REF: OFFICE BUILDING/CLAUDE SANCHEZ (H20-D10) DATED 6/29/83

REF: Office Building/Claude Sanchez (H20-D10)

REF: Office Building/Claude Sanchez (H20-D10) - 5/24/83

PROJECT TITLE Office Bldg./Claude Sanchez TYPE OF SUBMITTAL Drainage Plan  
 ZONE ATLAS PAGE NO. R-2010 CITY ADDRESS 8618 Menaul Blvd. NE  
 LEGAL DESCRIPTION Lot L-1B, Block A, Snow Heights Addition  
 ENGINEERING FIRM Bryant Engineering CONTACT Dick Bryant  
 ADDRESS Box 4604, Albq. 87196 PHONE 836-6455  
 OWNER Claude Sanchez CONTACT \_\_\_\_\_  
 ADDRESS 4400 Alvara Ave., N.E. PHONE 345-4304  
 ARCHITECT Bill Buckley CONTACT Frank Mackey  
 ADDRESS 740 San Mateo Blvd. NE PHONE 255-9196  
 SURVEYOR Adam, Hamlyn, Anderson CONTACT Jake Bordenave  
 ADDRESS 4055-A Montgomery Blvd. NE PHONE 881-1808  
 CONTRACTOR Claude Sanchez CONTACT 345-4304 or 255-3224  
 ADDRESS \_\_\_\_\_ PHONE \_\_\_\_\_

DRAINAGE PLAN
H20 - D10

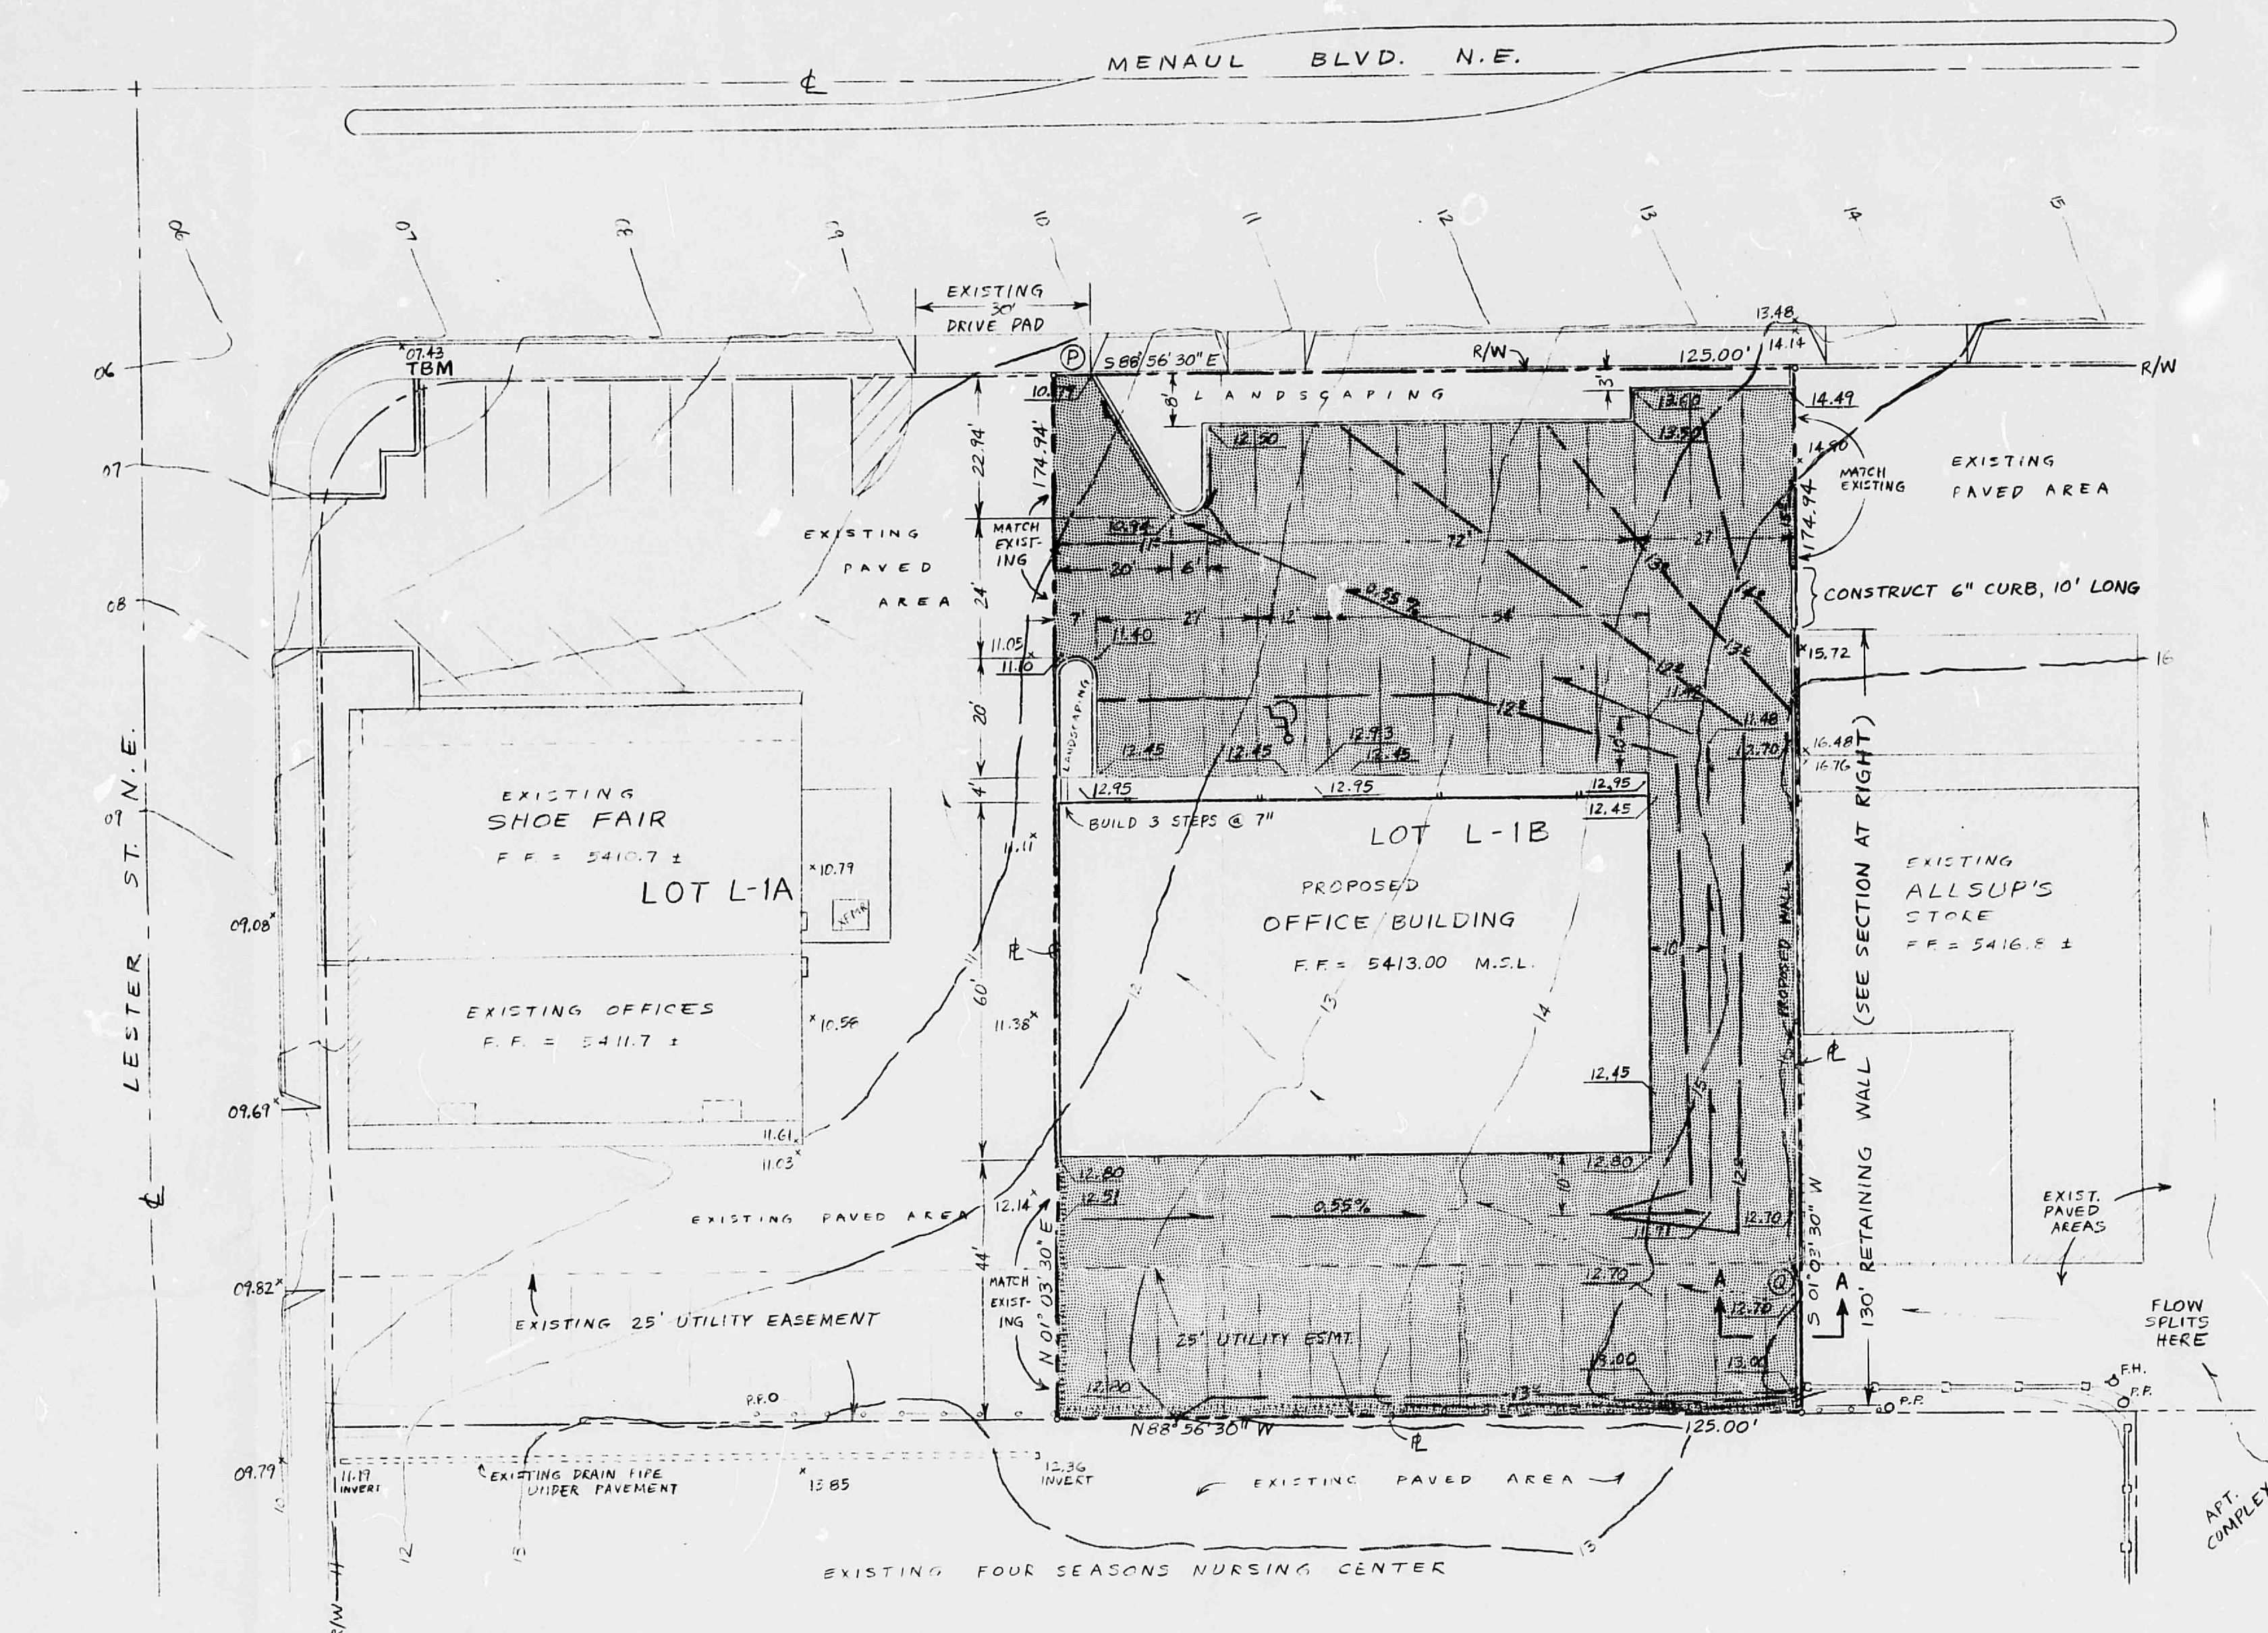
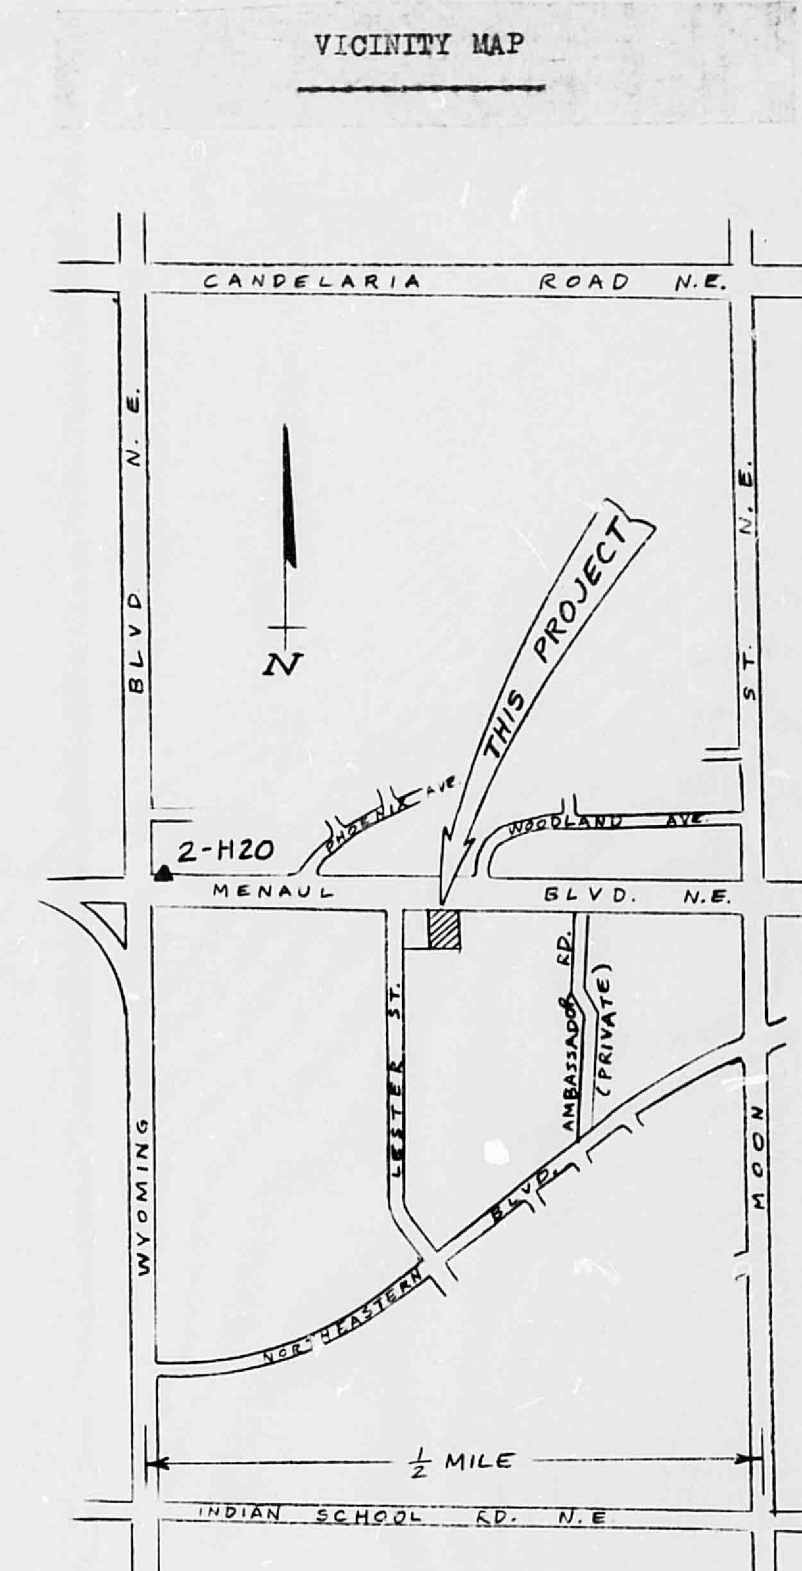
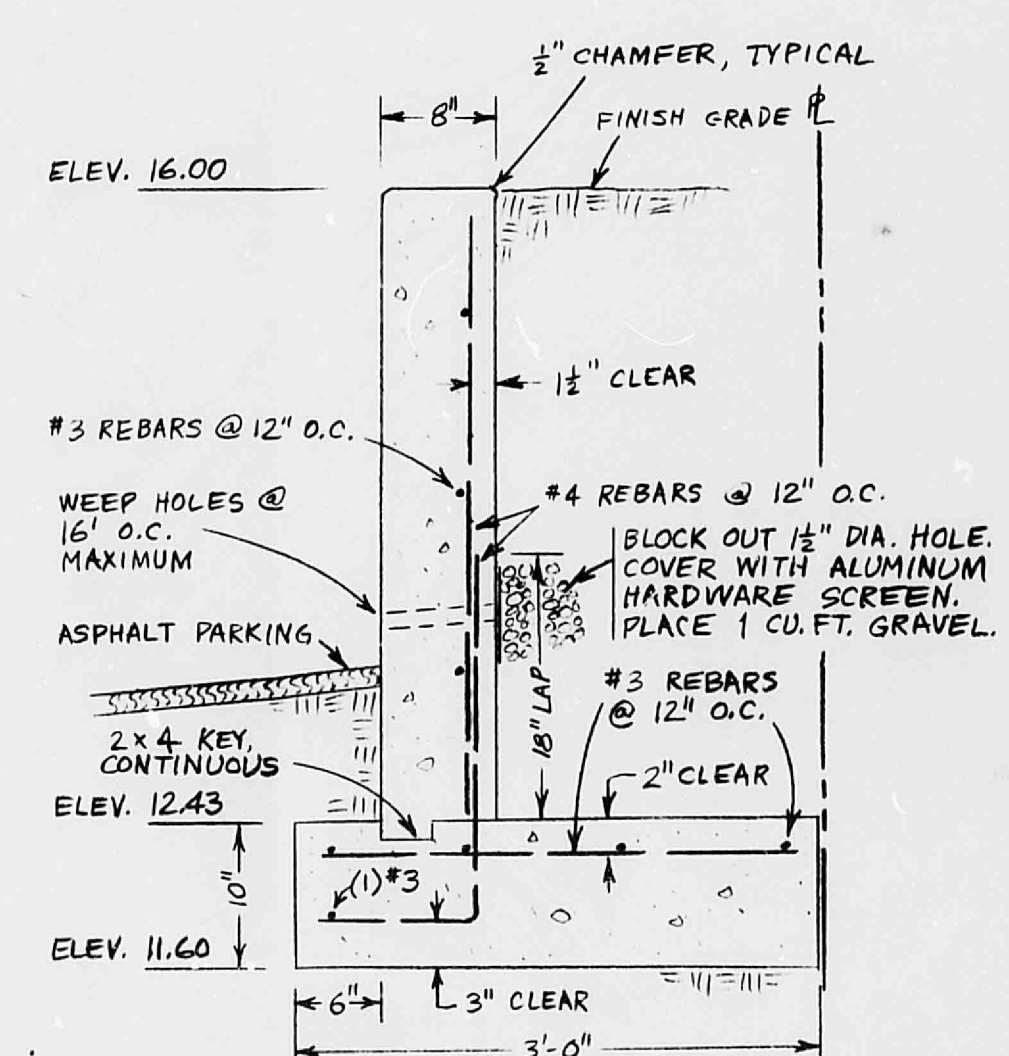
1. A private drainage easement is required for drainage across lot lines; more specifically, drainage across Lot L-1A.
2. Provide legible contours and/or spot elevations at the property lines for the existing and proposed grading.
3. Indicate location of roof drain.

In either case (i.e., drainage across lot lines or directly into Menaul) a cross section will be provided to show the proposed grading and retaining wall requirements at the S.E. corner of the site.
